**Environmental Assessment Exhibition – Mixed Use Residential Development at
Discovery Point, 1 Princess Highway, Wolli Creek (MP10_0030)**

The DoT has reviewed the Environmental Assessment (EA) report and requests that the
following matters be addressed and included in the final Statement of Commitments
and/or conditions of consent:

## Discovery Point, Wollri Creek Concept Plan Street Setout

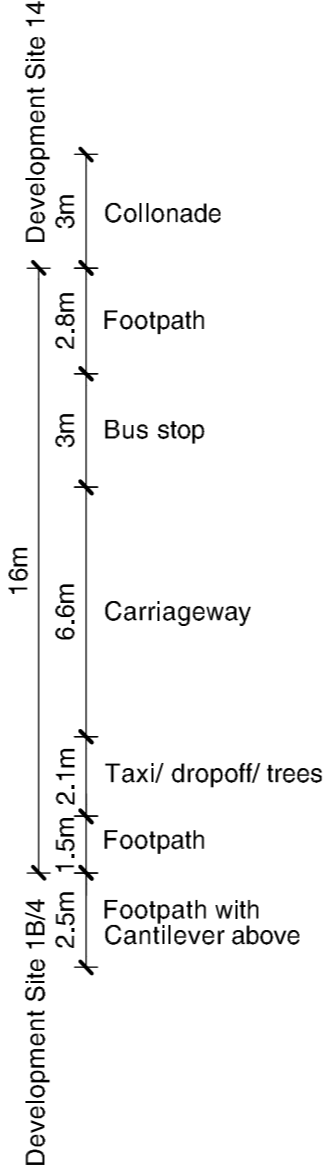
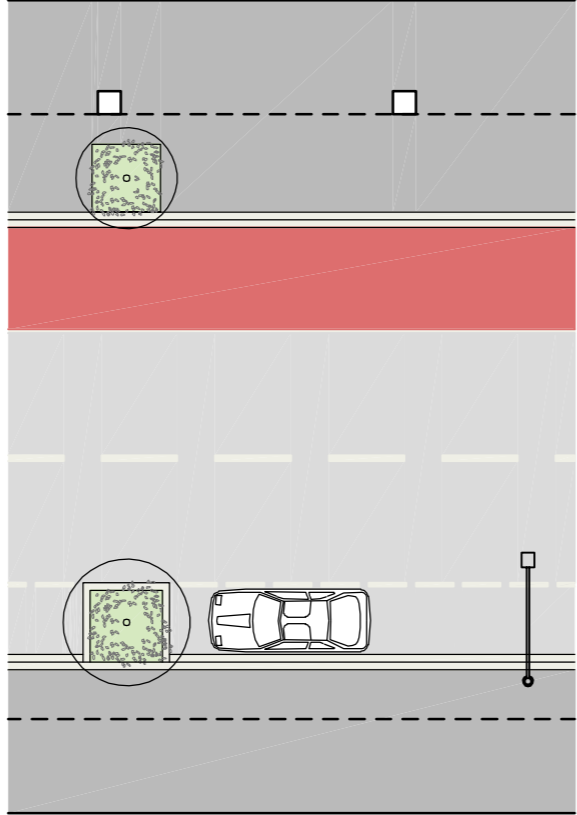
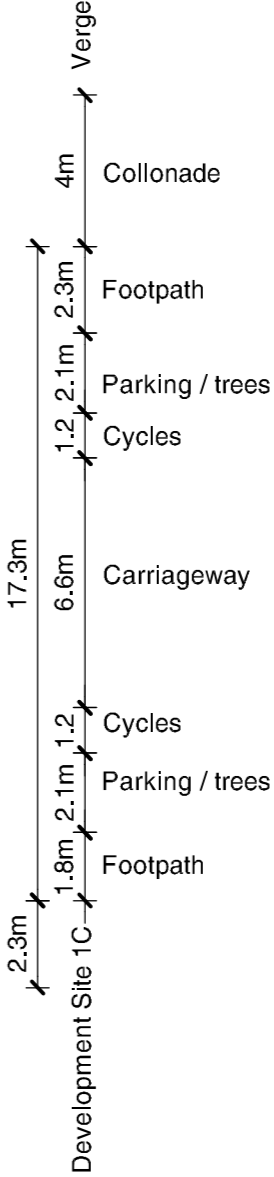
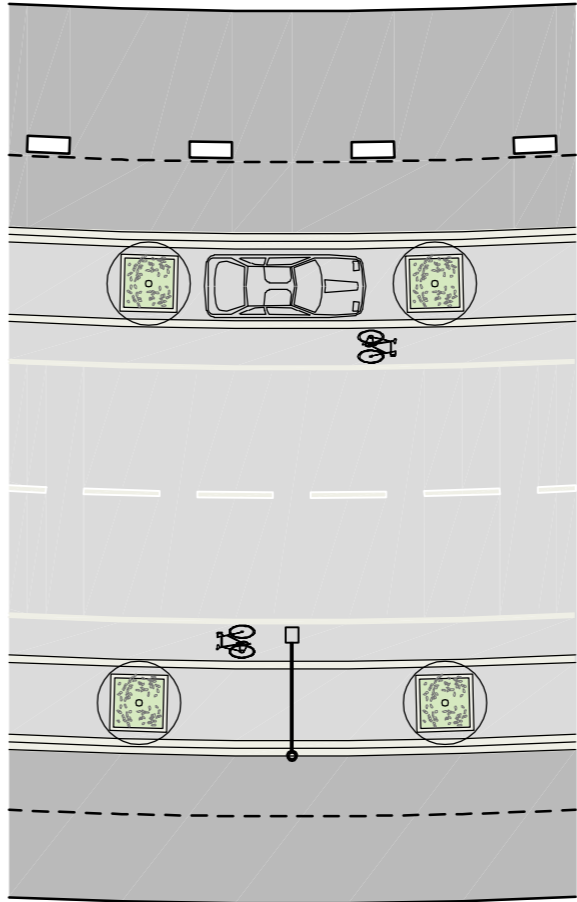
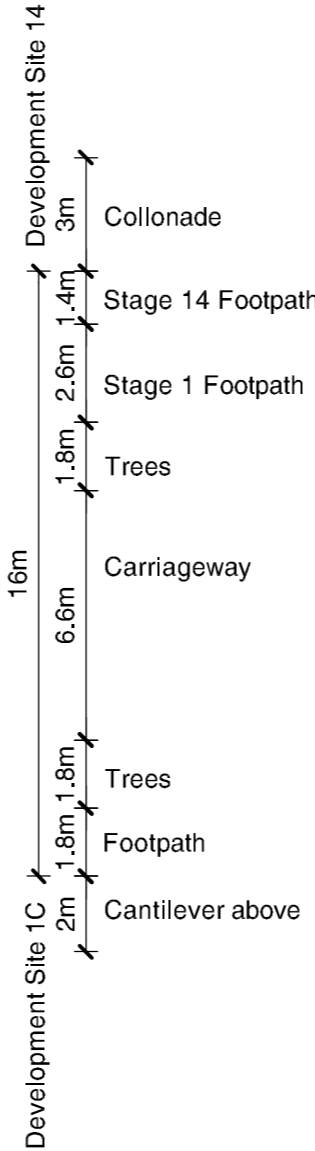
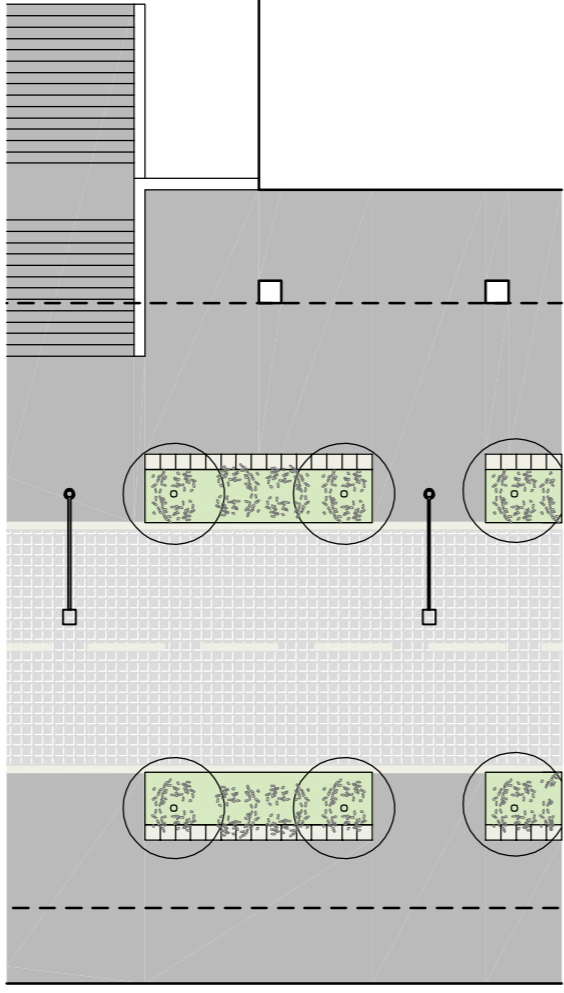
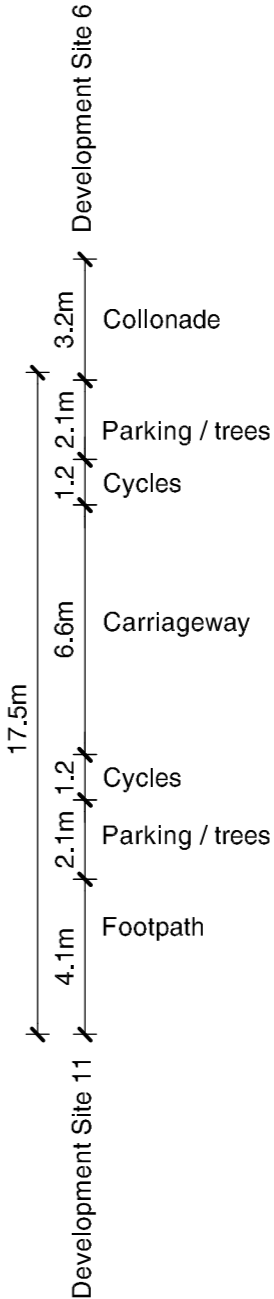
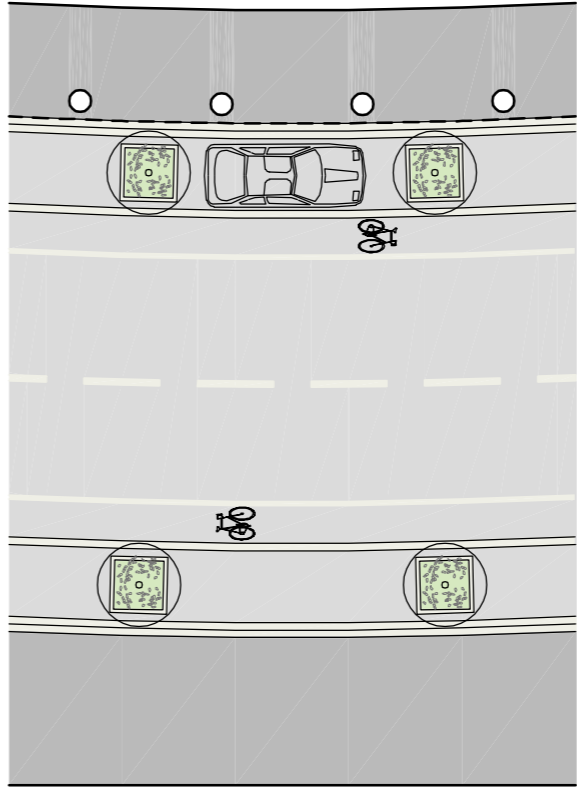
- It is noted that the combined widths of car parking and cycle lanes along the Brodie Spark Drive (as shown on the street set out diagram DA3-101 prepared by Bates) are only 3.6 m (2.5m car parking and 1.2 m bicycle). This is less than the Austroads desirable minimum of 4.0m as well as the acceptable minimum of 3.7m. The set out of Brodie Spark Drive should be revised to ensure the compliance;
